KITTITAS COUNTY COMMUNITY DEVELOPMENT SERVICES

May 23, 2018

Subject: Blackhorse Final Development Plan – Minor Amendment Request – Request for additional information

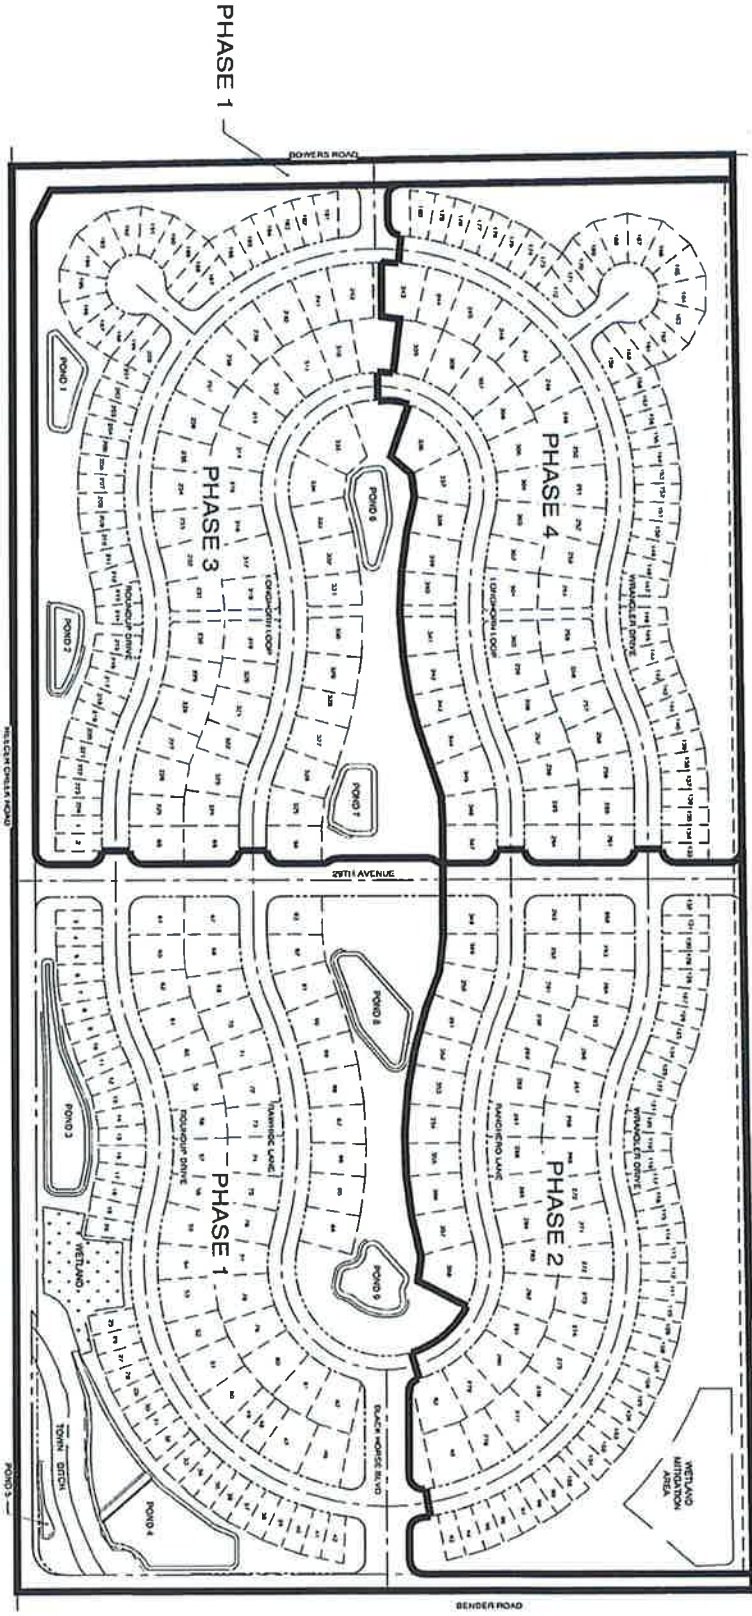
1. Revise the phasing map to remove the identified parking area from Lot 46; and
2. Revise the phasing schedule table to include Lots 1 & 2. Currently they are not mentioned within the phasing schedule table.
